CITY OF ALBUQUERQUE

**Re: Defined Fitness, Unser Crossing
Erosion and Sediment Control Plan
Engineer's Stamp Date 10-11-18 (K10E045B)**

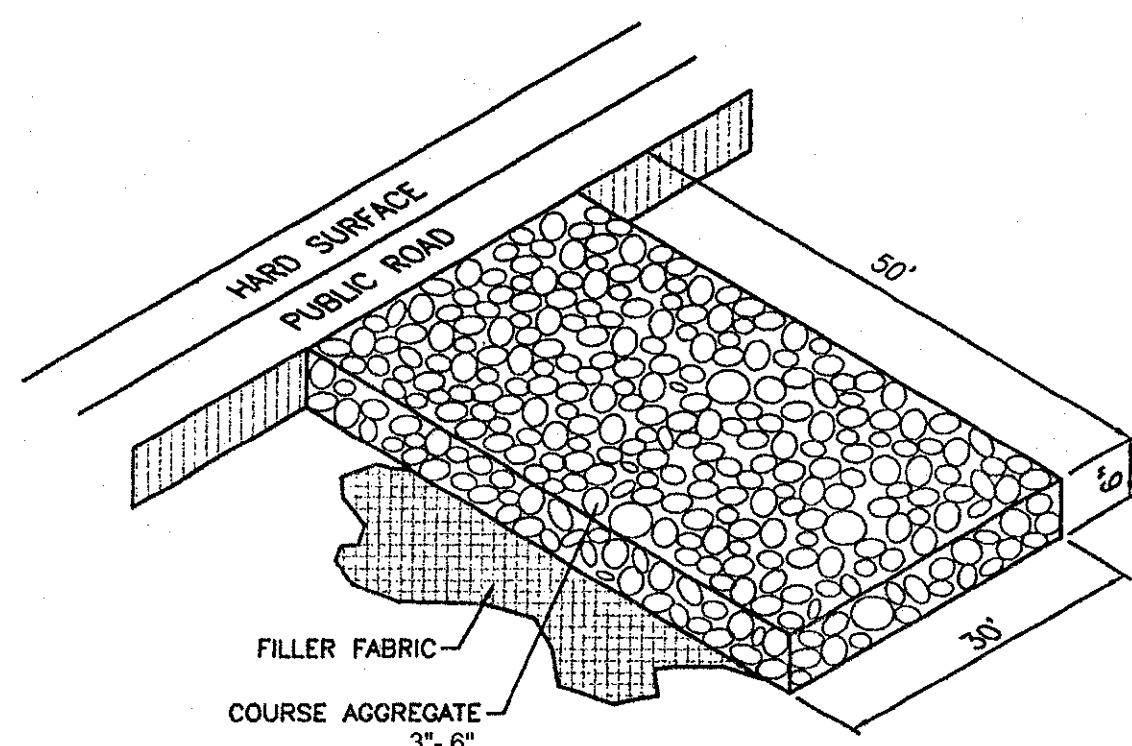
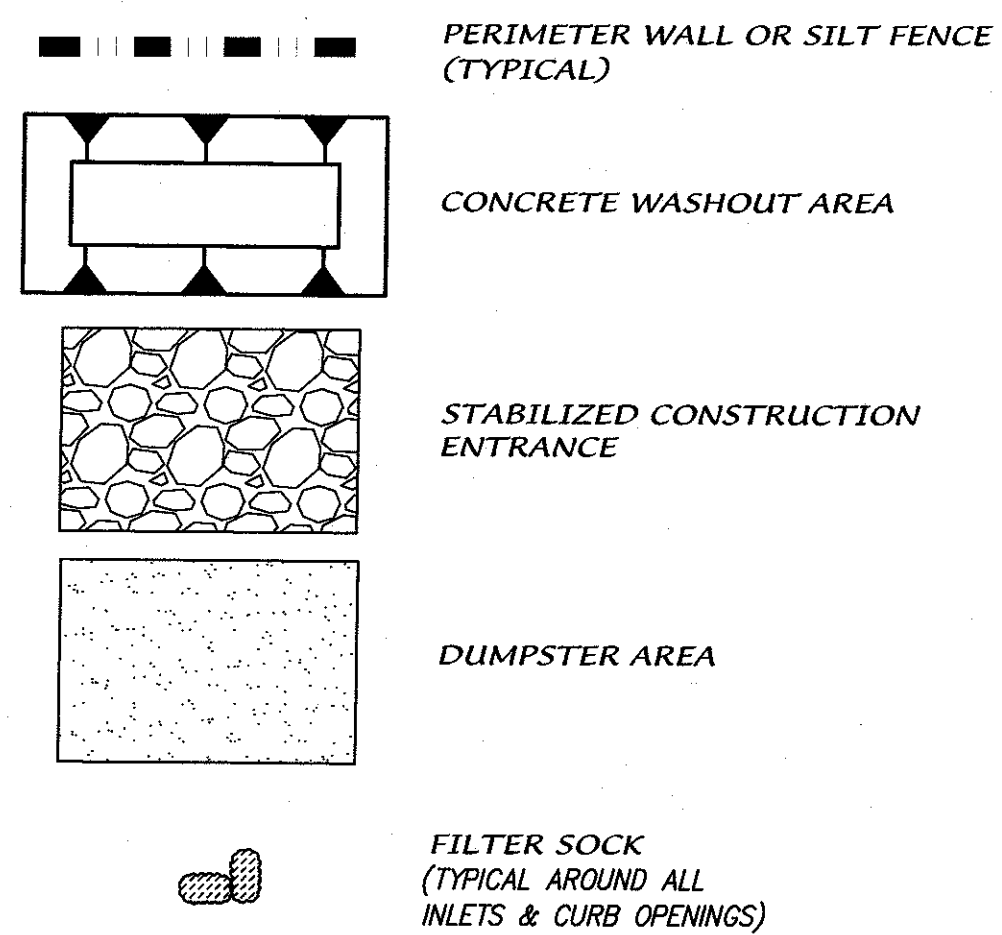
1. Provide existing and proposed grades. The simplest way may be to superimpose BMPs on the grading and drainage plan.
2. Please change "Filler Fabric" to "Filter Fabric" in the Stabilized Construction Entrance detail.
